Please ask for: Mrs D Johnson
Email: daun.johnson@arun.gov.uk
Telephone: 01903 737762
Our Ref: BR/114/20/PL
Your Ref:
Date: 18th May 2020

Application for Planning Permission

Development: Conversion of existing vacant residential care home into 10no. flats
Location: 13-17 Abbeyfield Richmond Avenue Bognor Regis PO21 2YE

PROPOSED SOUTH ELEVATION

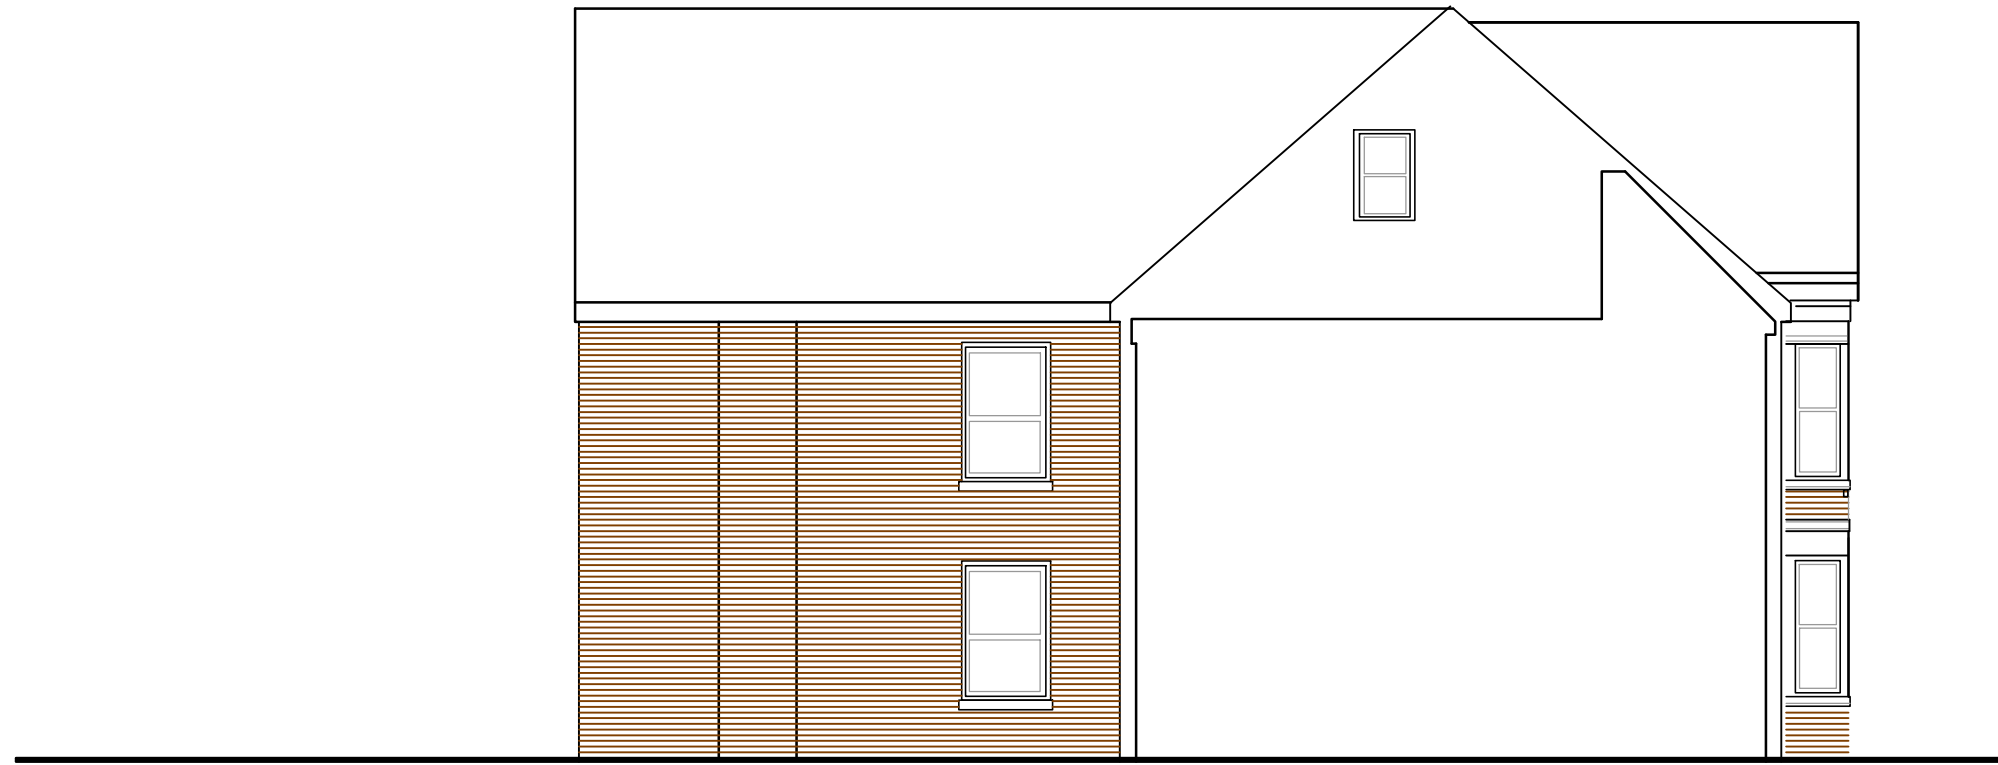
The proposed south elevation and first floor plan do not accord. Please amend accordingly.
